**Subject:** Meeting Notes for NEPA/404 Merger Team Concurrence Point 4B  
TIP Project B-4929 (Topsail Island Bridge Replacement)

A NEPA/404 Merger Team meeting for the subject project was held on March 12, 2015 in NCDOT's Structure Design Conference Room. The purpose of this meeting was to reach agreement on Concurrence Point (CP) 4B (30% Hydraulic Review).

**Presentation:** Mr. Bollinger presented a PDF of the 30% redline drainage plans, and discussion included the following:

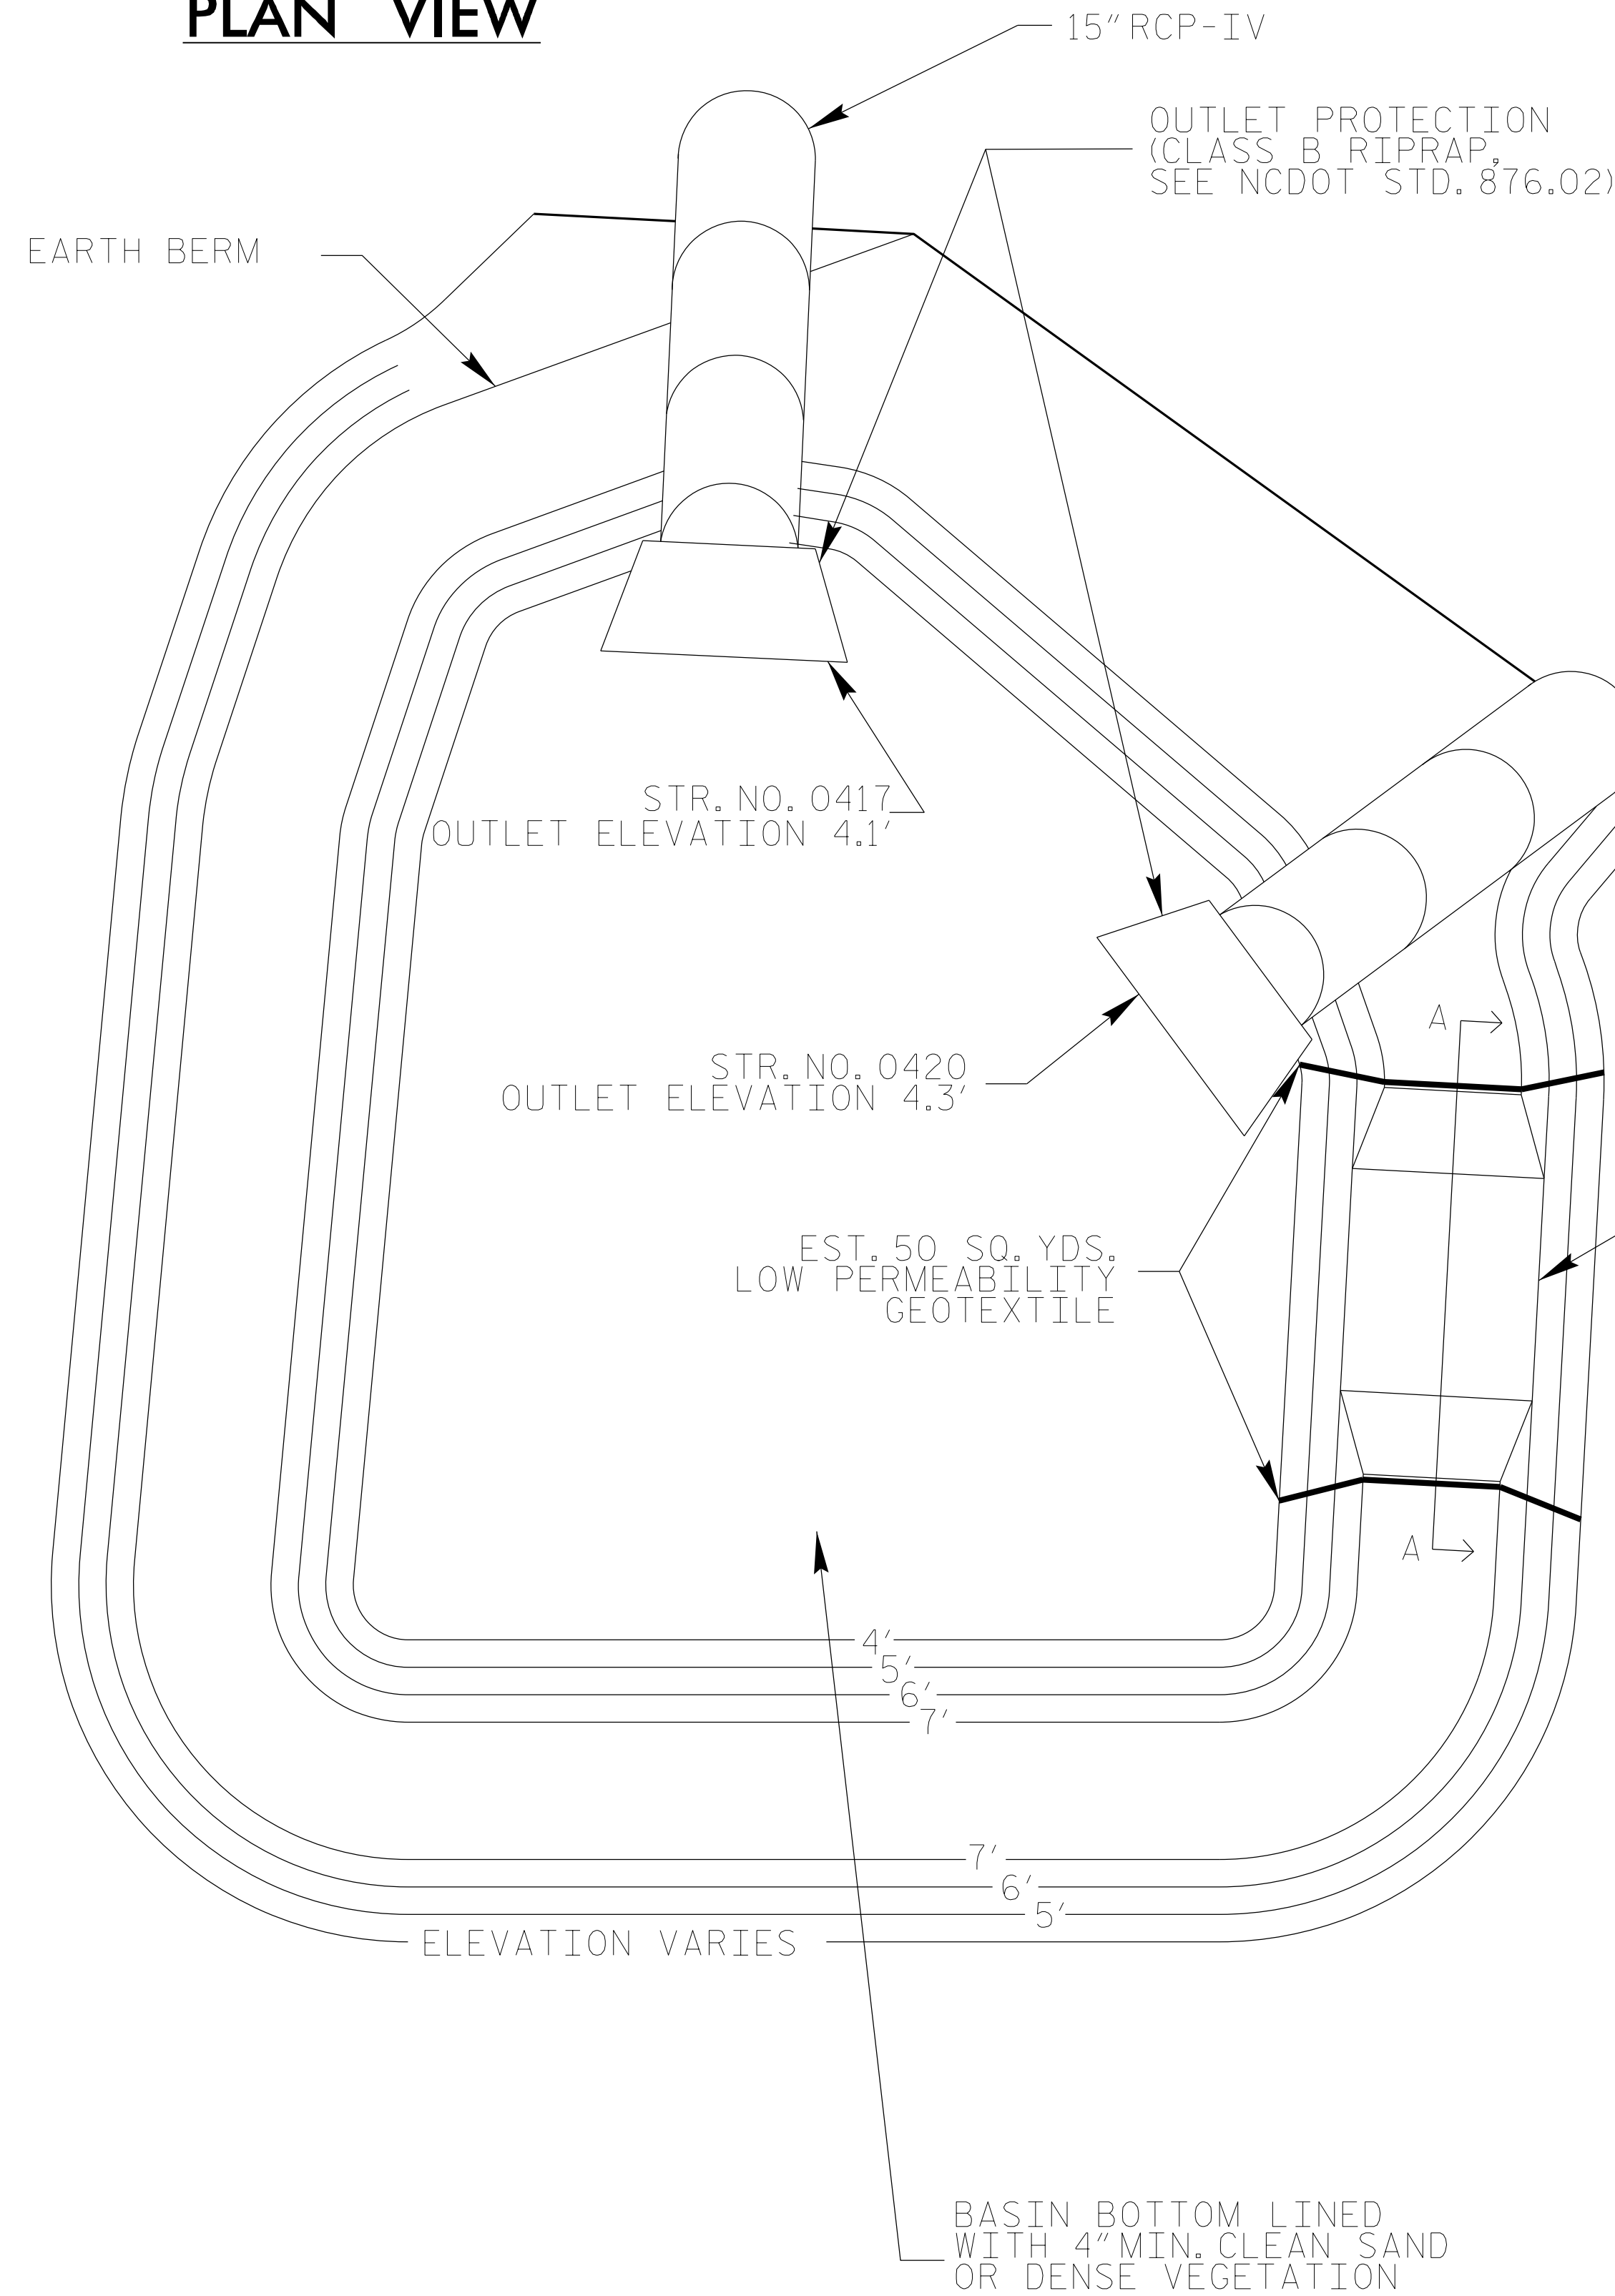
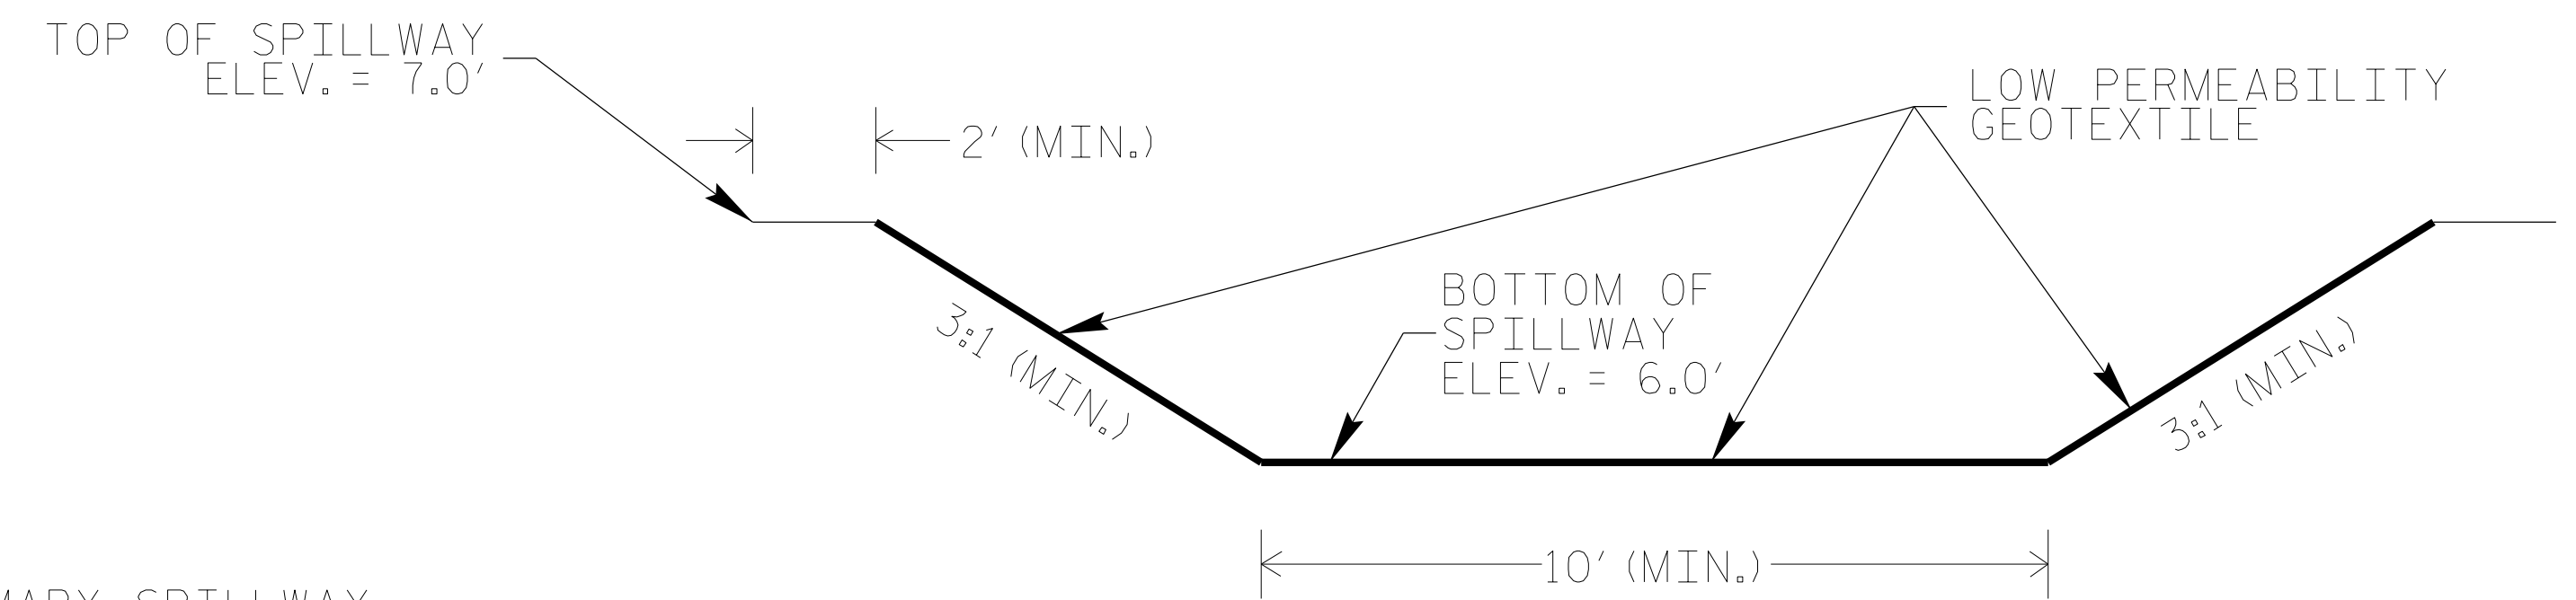
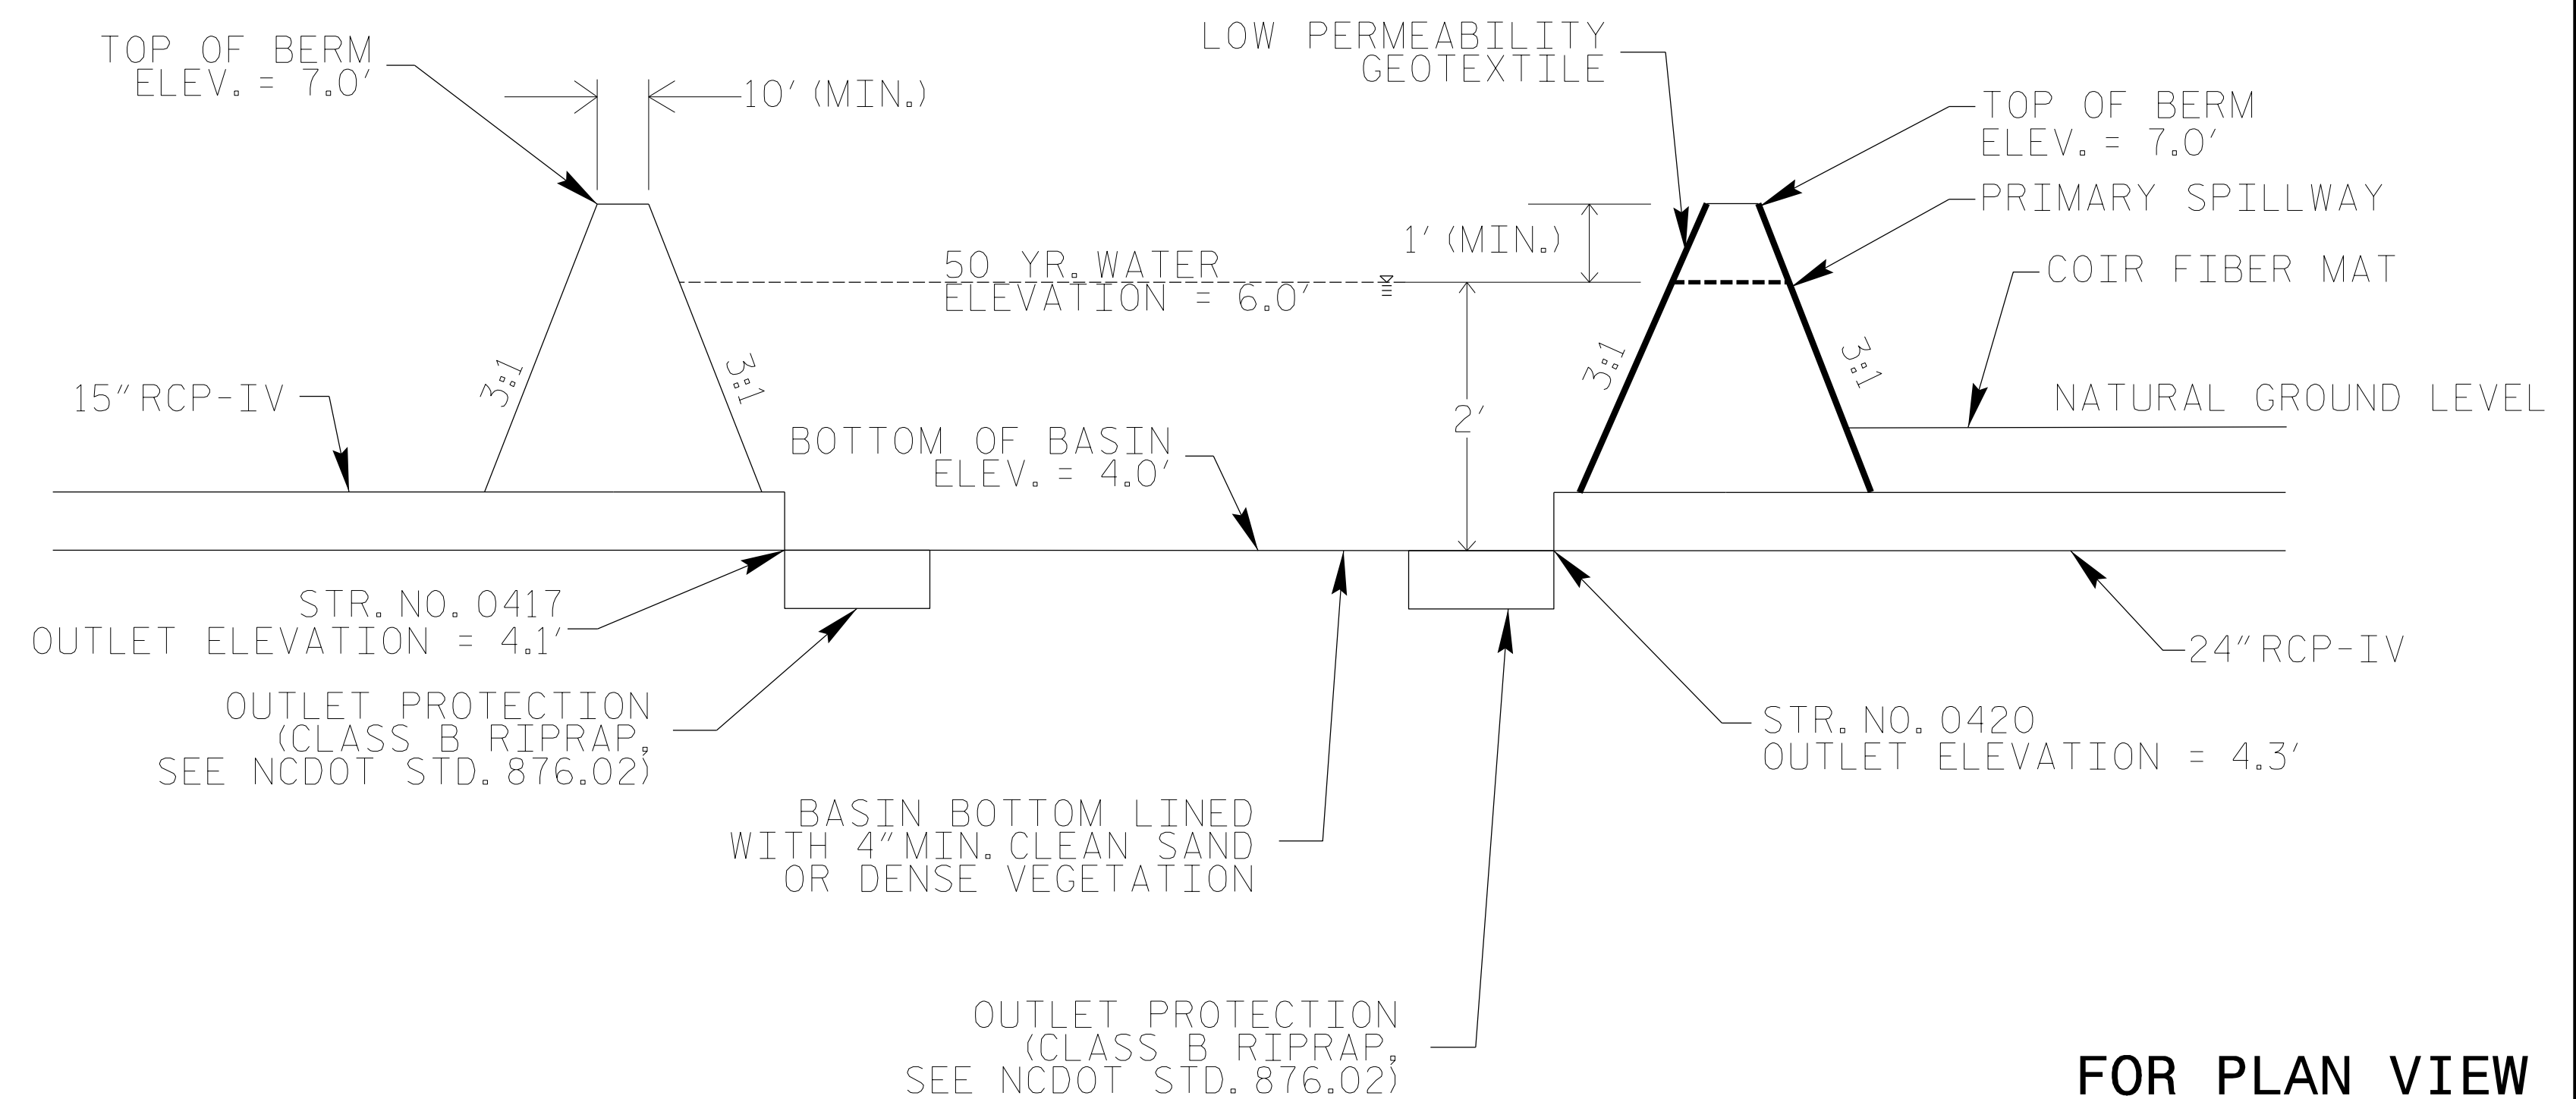
**MT Comment:** *Drainage basins should be located outside of wetlands and CAMA buffers (30 feet of the shoreline).*

**MT Comment:** *Mr. Herndon requested that NCDOT exhaust every option for treating all stormwater runoff from the bridge before proposing deck drains. MT attendees generally disapproved using deck drains over open water, particularly over Submerged Aquatic Vegetation (SAV) habitat.*

**MT Question:** *Would it be possible to use infiltration trenches (as used on Oak Island, for example)?*

**MT Response:** (Post 4B Meeting) Mr. Lane has visited the site and has reviewed the proposed stormwater basin adjacent to the existing bulkhead on the south end of the project. Mr. Lane has determined that the stormwater basin would be beyond the 30' CAMA buffer and will not be in conflict with the buffer.

**PT Response:** Noted. Basins shown on the 30% hydraulic plans are subject to change and will likely be resized/relocated to minimize impacts. SAV surveys are scheduled for the summer prior to construction, and NCDOT will further refine the hydraulic plans in upcoming months.

**PT Response:** NCDOT will explore this option.
